Mallard Pass Solar Farm

Schedule of Changes Draft Development Consent Order

Deadline 5 (5th September 2023)

EN010127/APP/9.3.5

X:\LDA_4990\2002_MALLARD PASS SOLAR FARM\CAD\1.0 CURRENT\1.0.1 SHEETS\PROWS\4990-2001-T-067-078 + 090-091-P2 - TRAFFIC REGULATION MEASURES PLANS - TEMPORARY ROAD CLOSURES.DWG

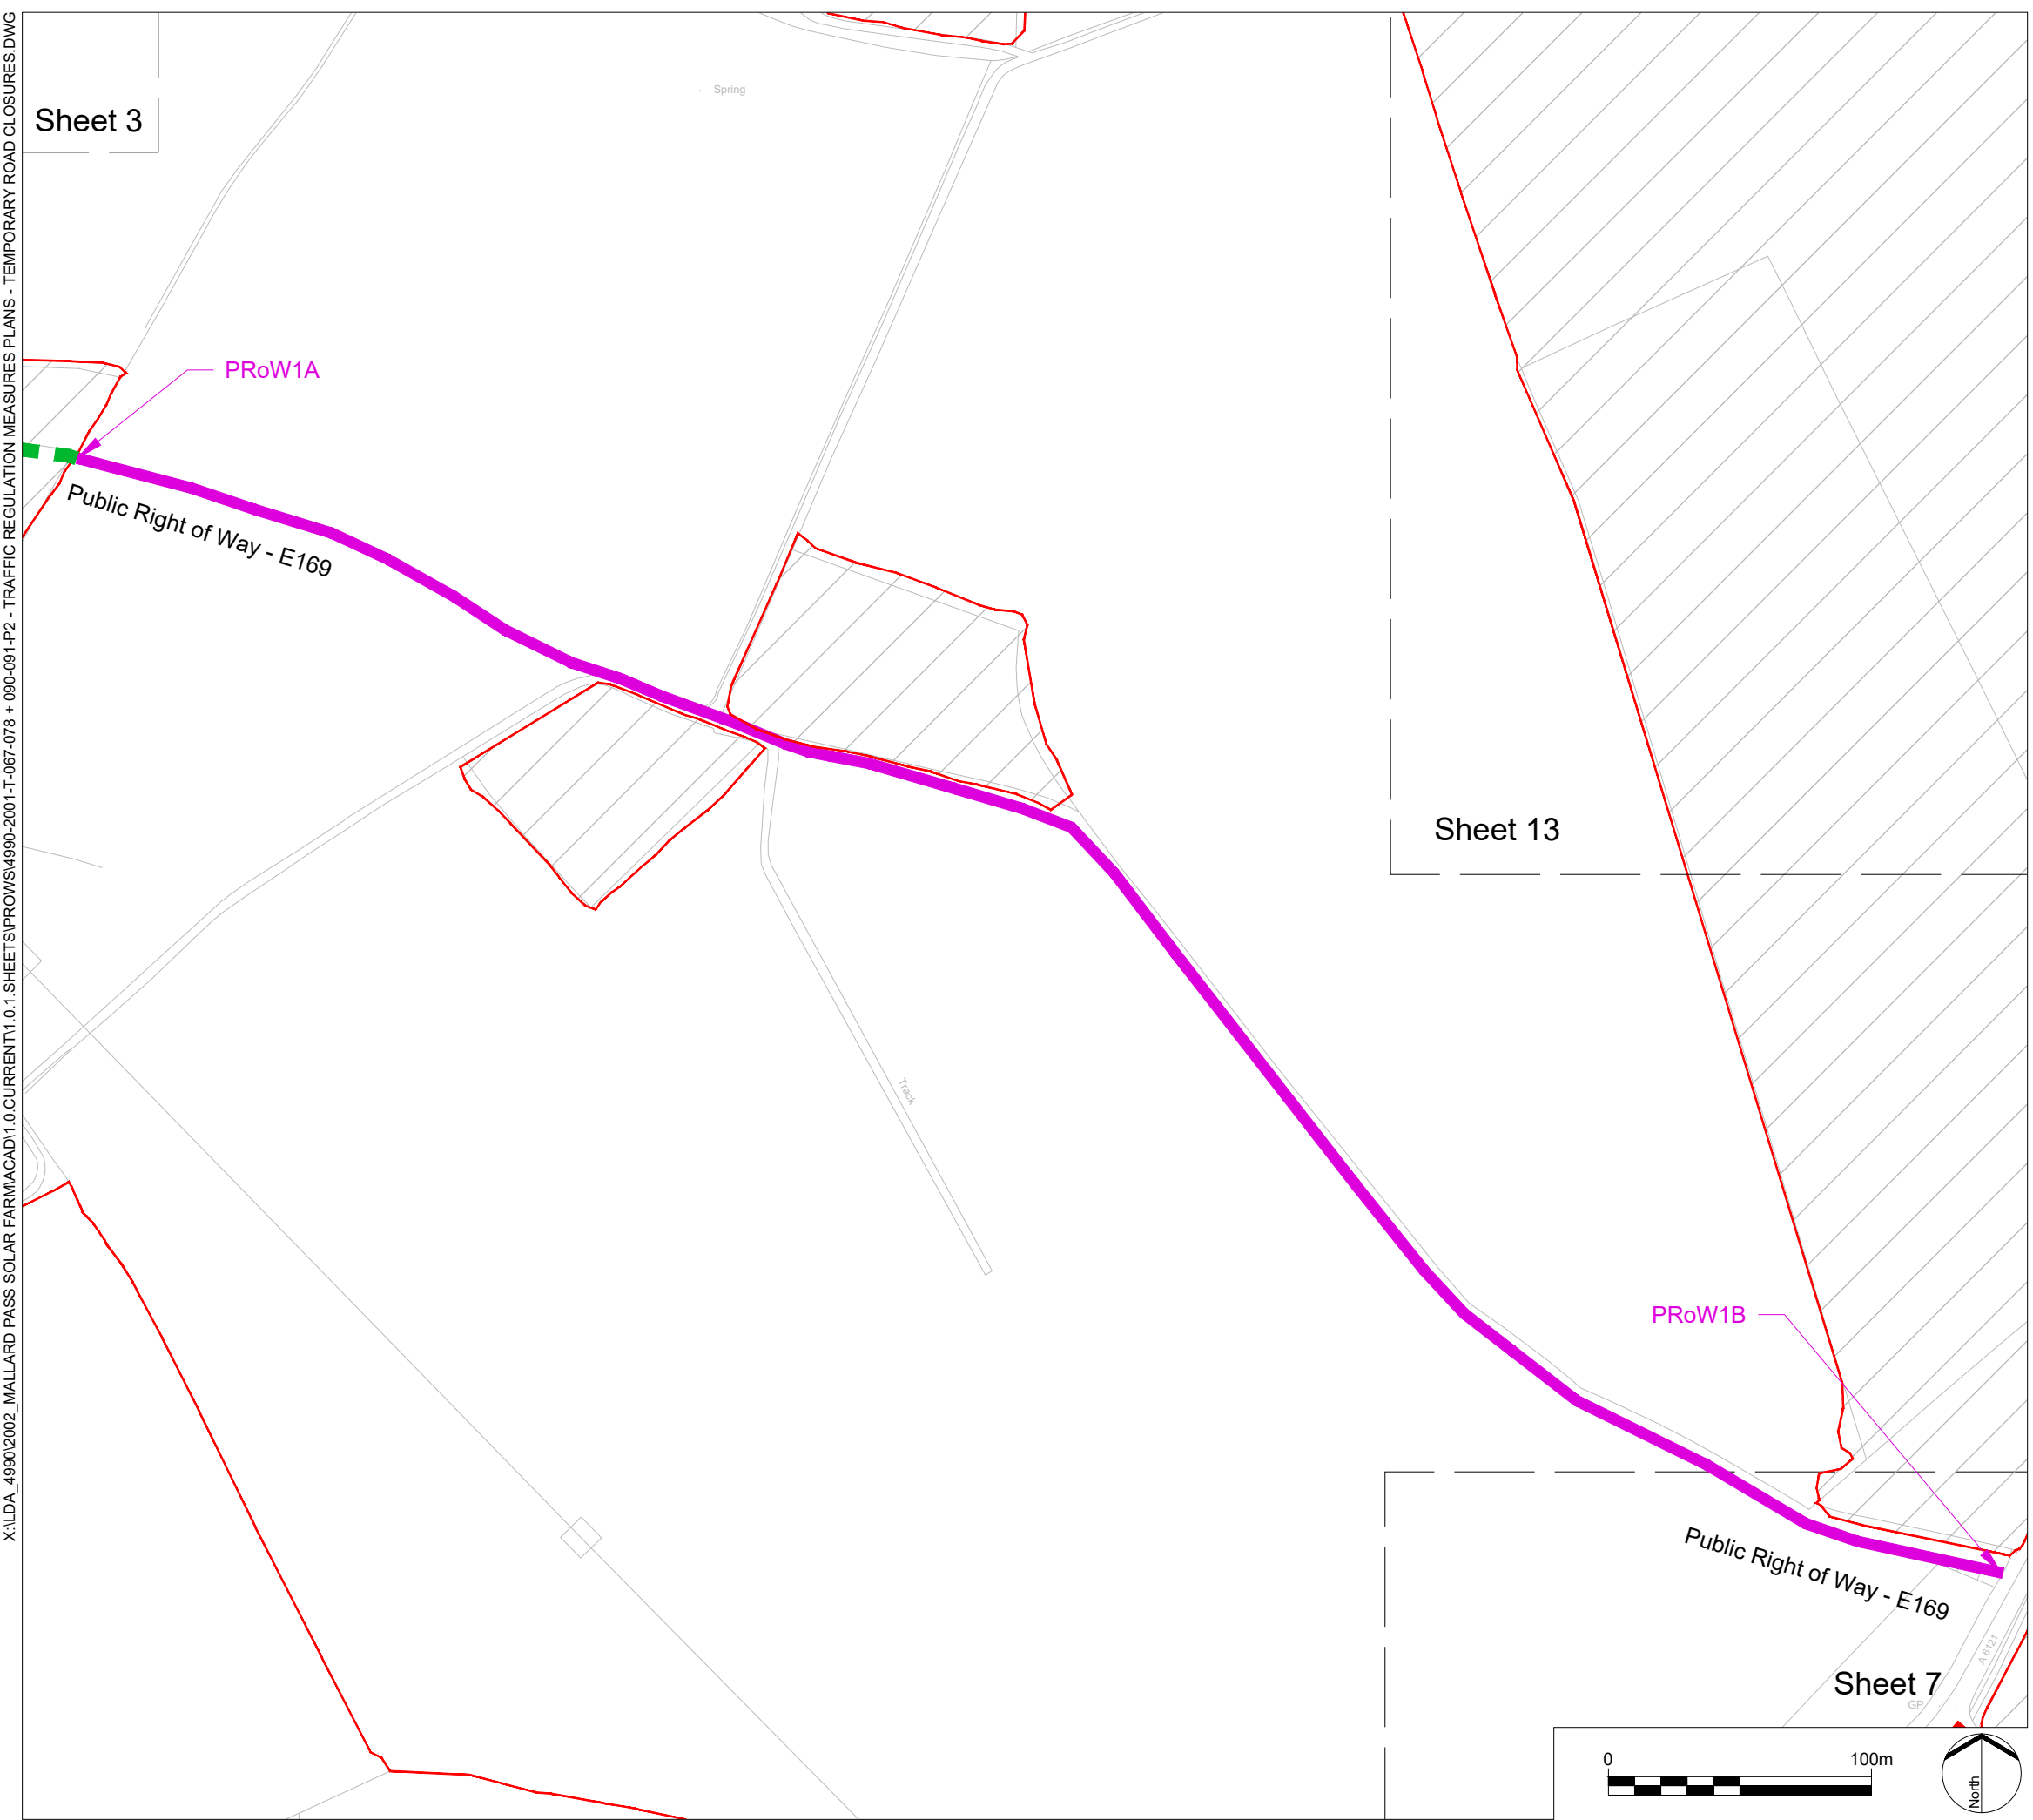
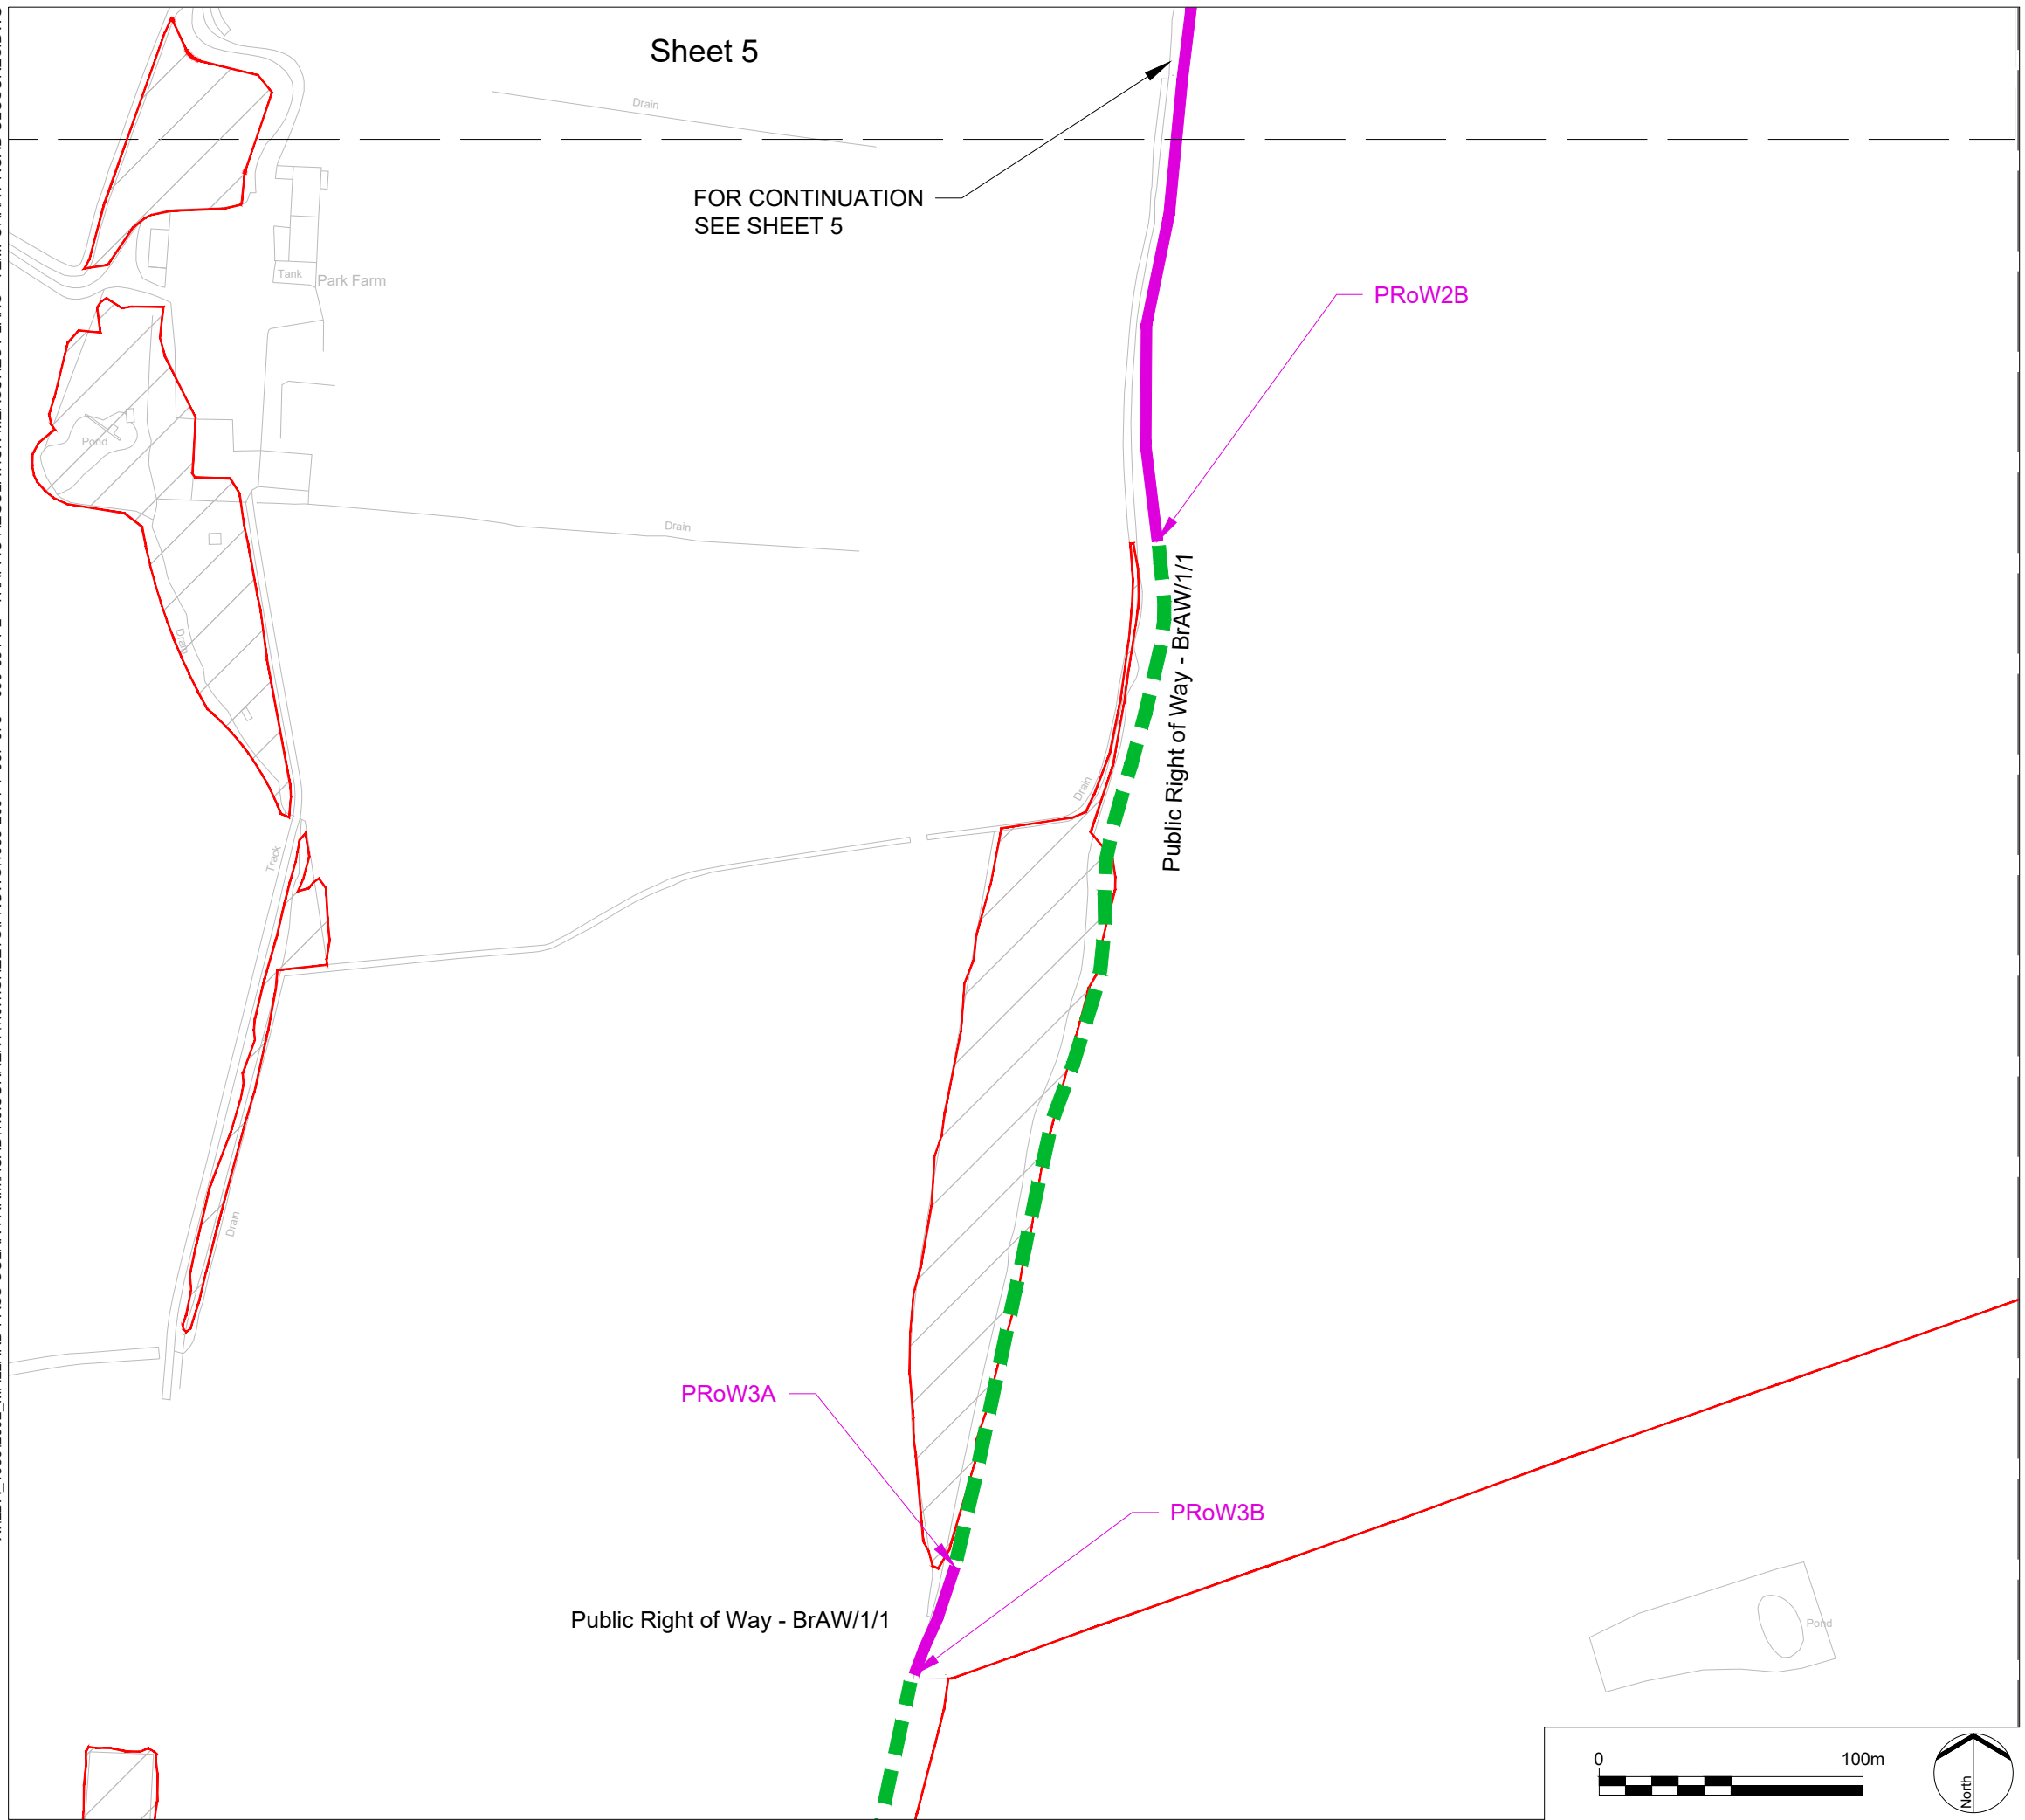
<p>draft Development Consent Order (Rev 0) to correct a typographical error.</p> <p>Other amends made to ensure Schedule is fully consistent with Access and Rights of Way Plans.</p>	
Schedule 8, Part 2	Insertion of an addition temporary road closure.	This has been inserted to reflect the updated traffic regulation measures plans – road closures (Rev 2) following comments made by MPAG at Deadline 4.	Deadline 5
Schedule 9	Amendment of definition of “vegetation maintenance rights” to include restricting or preventing the removal of vegetation.	Amended to provide further clarity on the extent of restrictive covenants sought (building on the similar drafting in the other 'categories' of rights in this Schedule) pursuant to article 22(2) following the ExA's Second Written Question 5.0.6.	Deadline 5
Schedule 4, 5, 6, 7, 8	Amendment from 'District' to 'Area'	Amended following the ExA's Second Written Question 5.3.1	Deadline 5
